From: Anita Gardner
Sent: 18 September 2013 14:28
To: Jason Hales ([REDACTED])
Subject: FW: Planning Consultation on: LU/241/13/L
Attachments: Toddington House, Wick 4.doc

2013
Site Address: Toddington House Toddington Lane Littlehampton BN17 6JX
Grid Reference: 503424 103745
Description of Works: Application for Listed Building Consent for the demolition of single storey pantry to north elevation and erection of kitchen extension.

DRWG. N° 740/P05-
SCALE 1:100 AT A3
© 26 JULY 2013

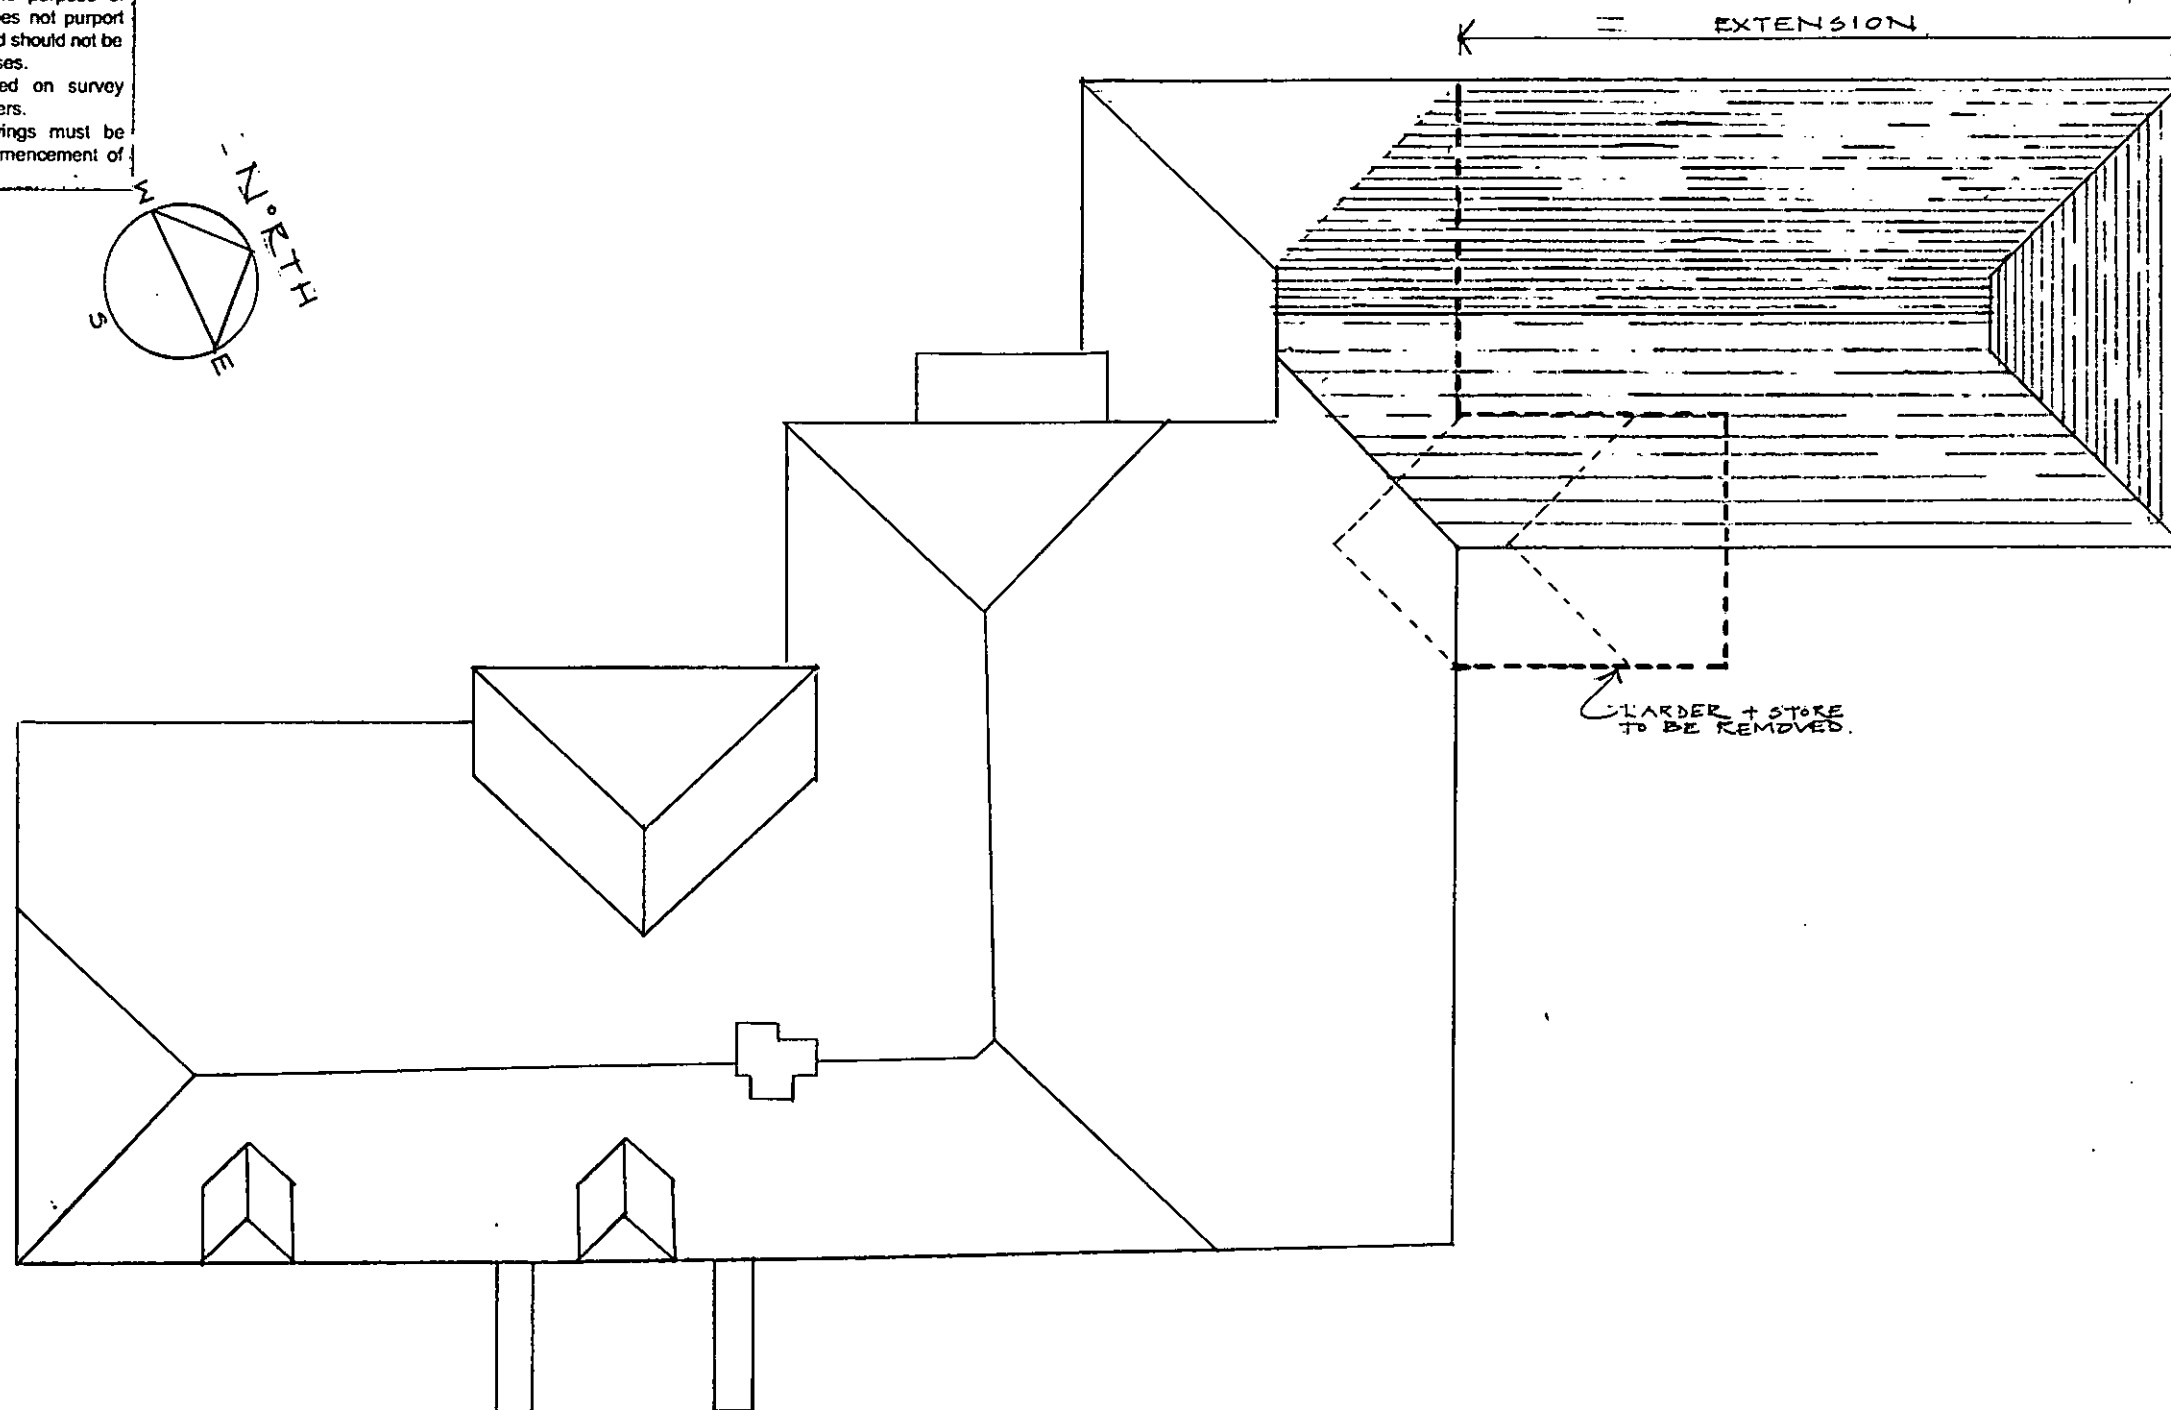
Accordingly, without prejudice, I would welcome receipt of amended plans reducing the length of the extension by approx. 2.5 metres. It would also be useful if the extract of the proposed ground floor plan could indicate the proposed uses of the ex, dining room, kitchen and library.
